Application No: M/98/25/HH
Site Address: 1 Elmer Court Elmer Middleton-on-sea PO22 6JT
Description of works: Extension and alterations to form a rear facing balcony and sliding doors (part retrospective).

Thank you for your internet representation made on 4th February 2026 which has been recorded as an objection with the comments as follows:

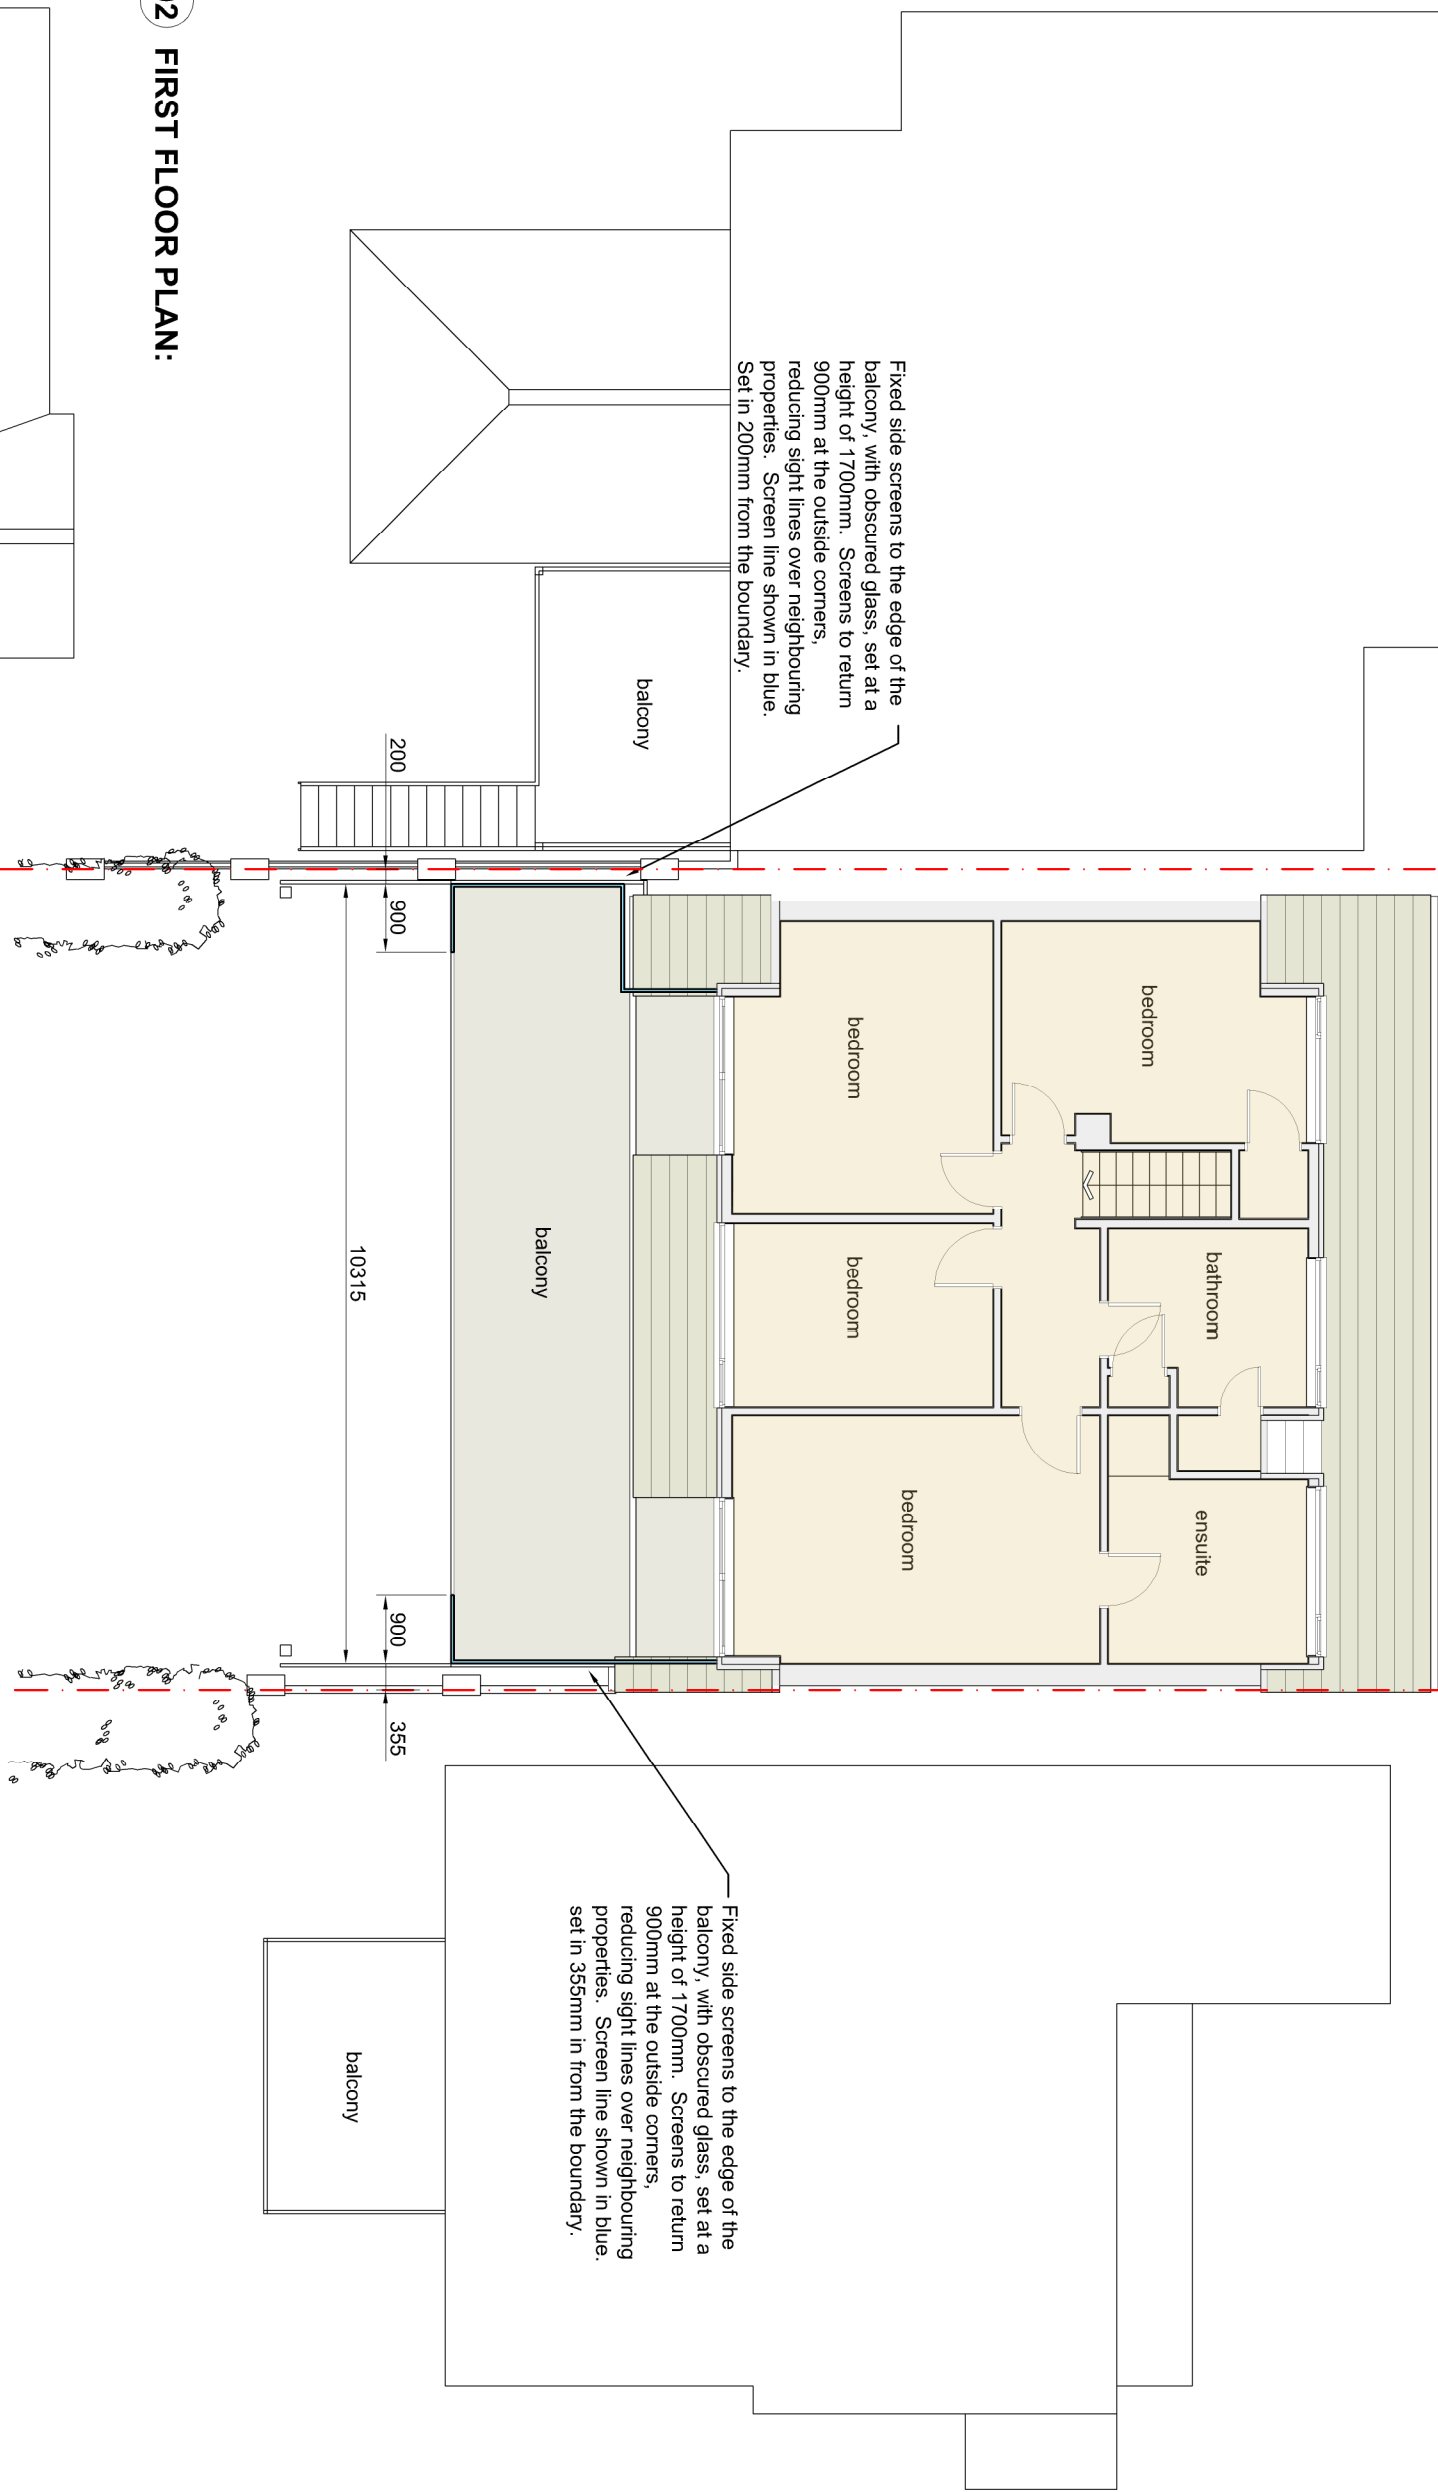
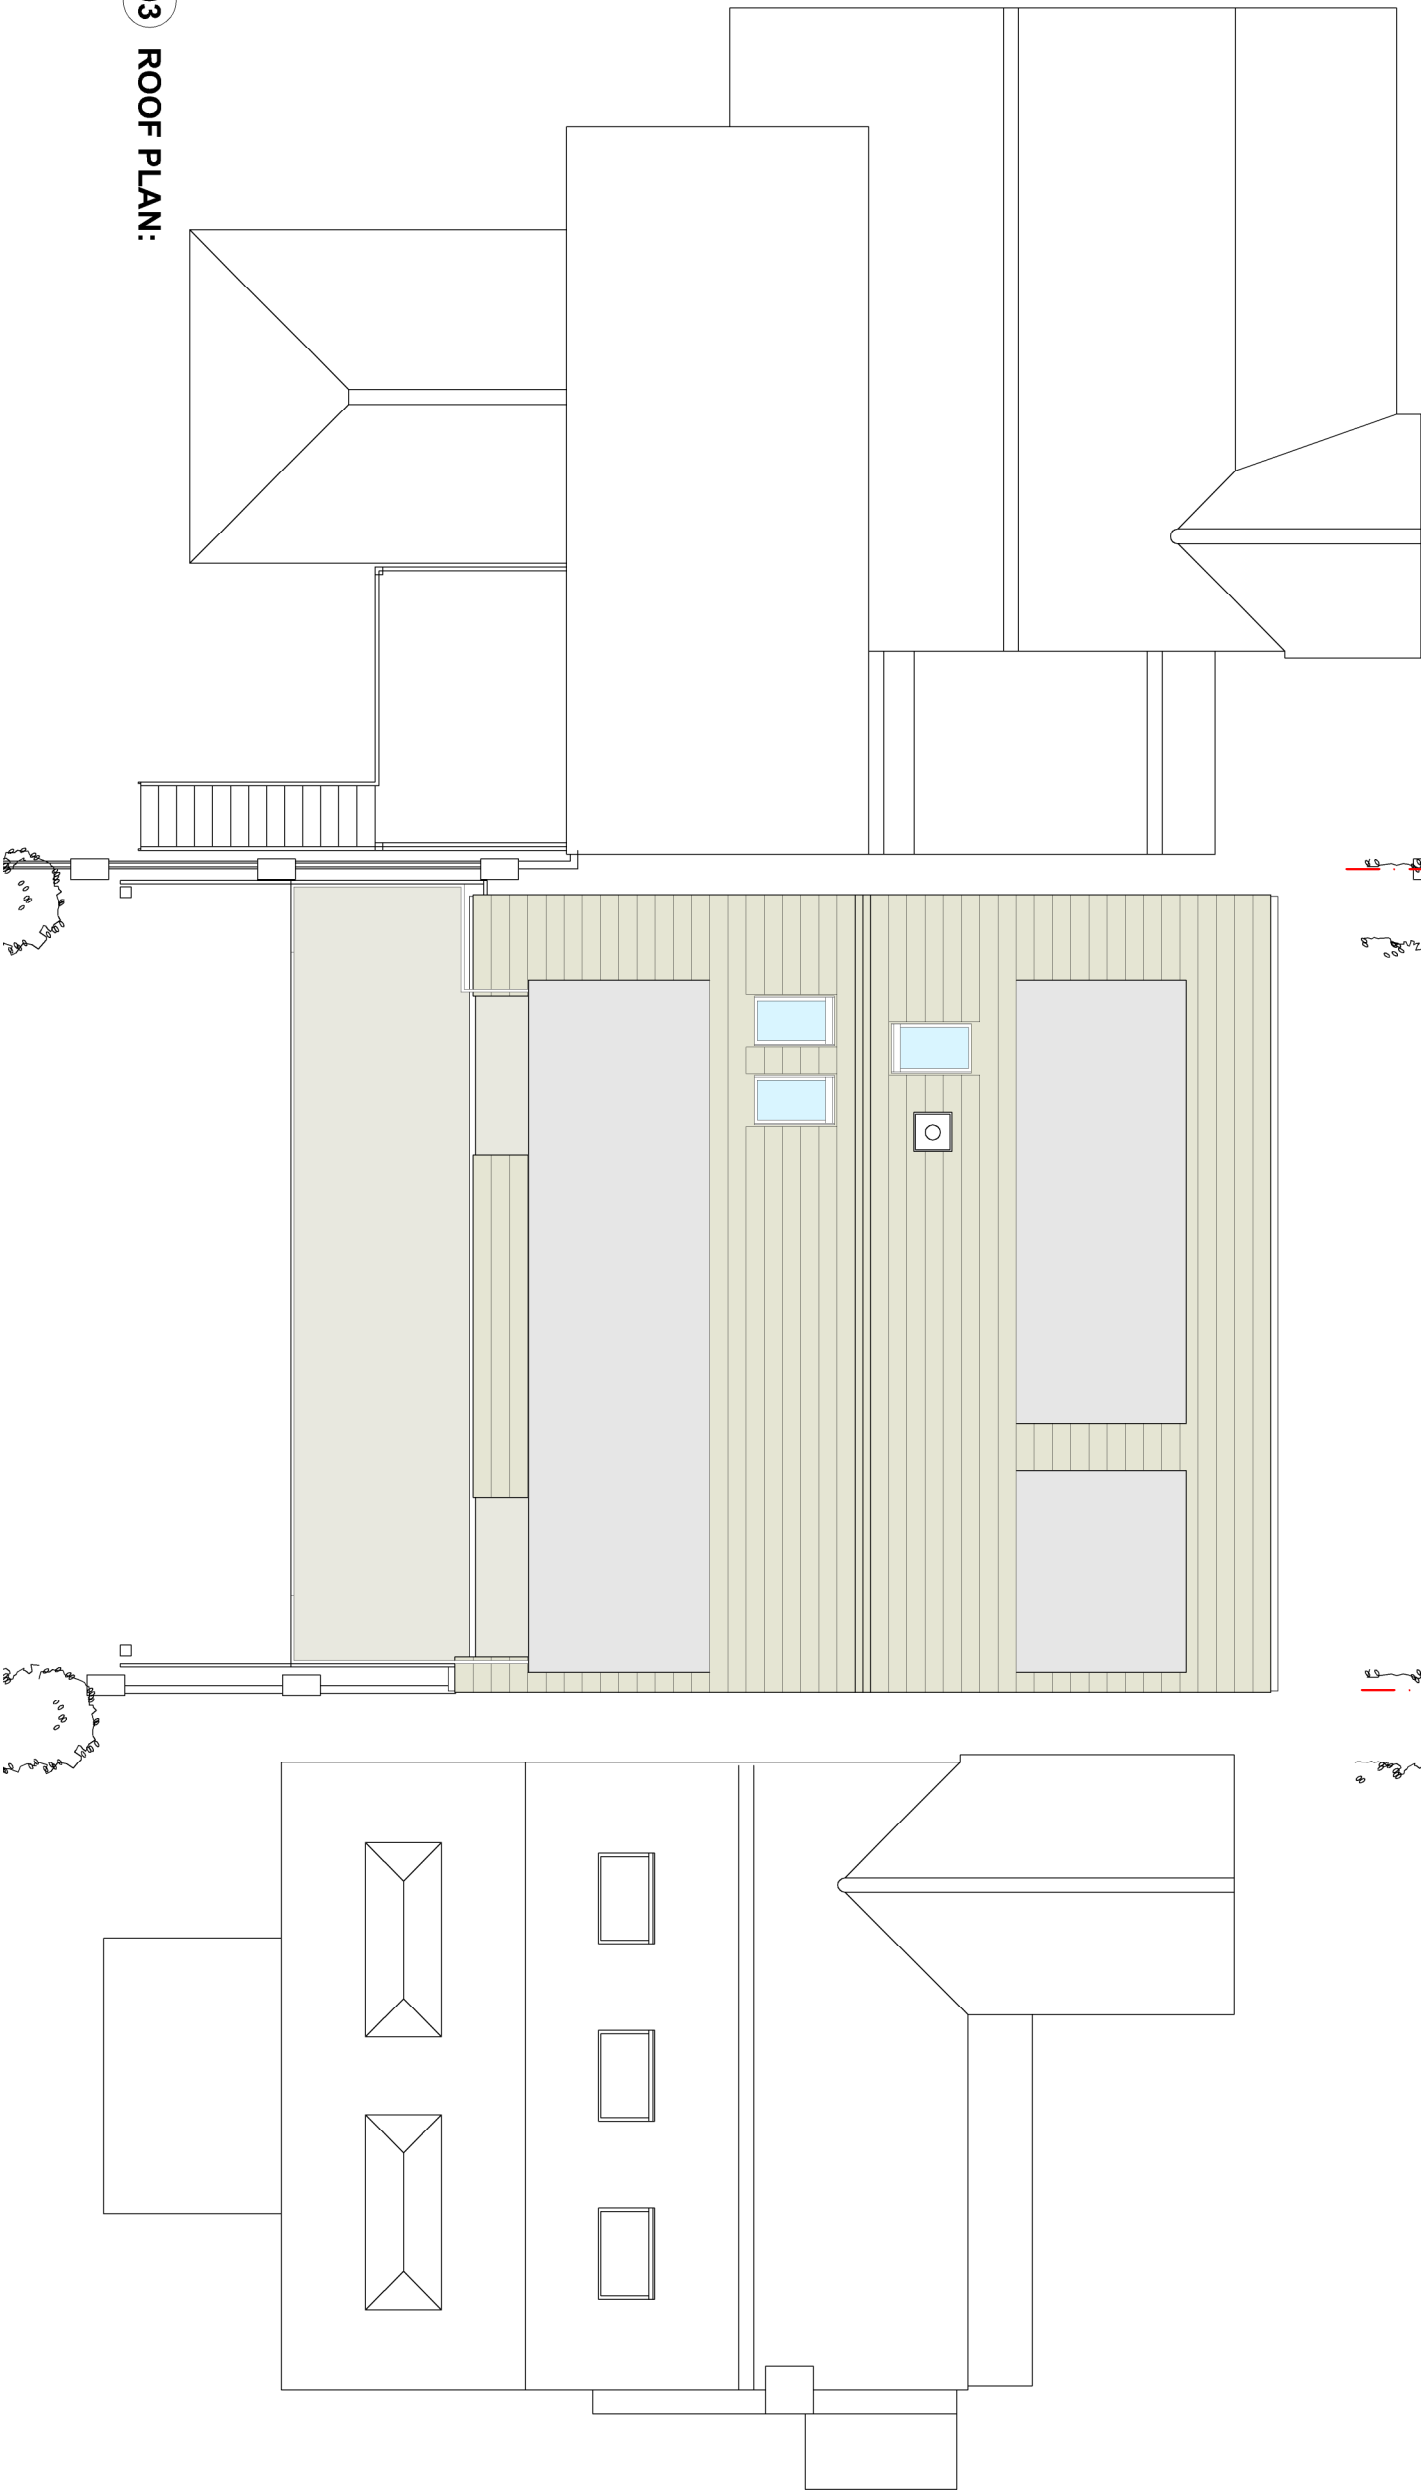
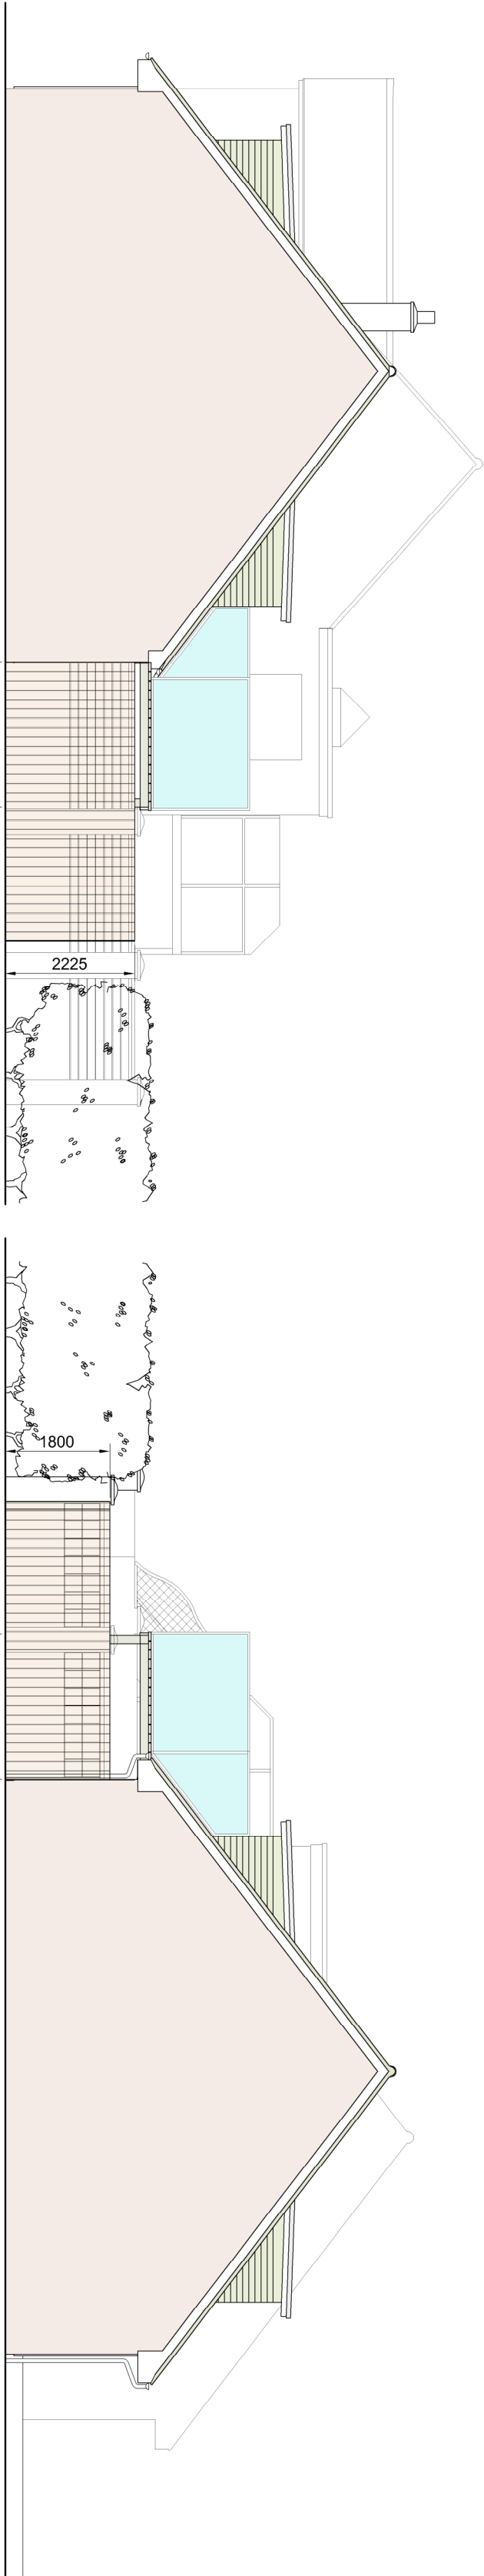
The proposed balcony sets a precedent in that it goes right across the house .
I would be concerned that the neighbor's either side of 1 Elmer court would have some loss of privacy
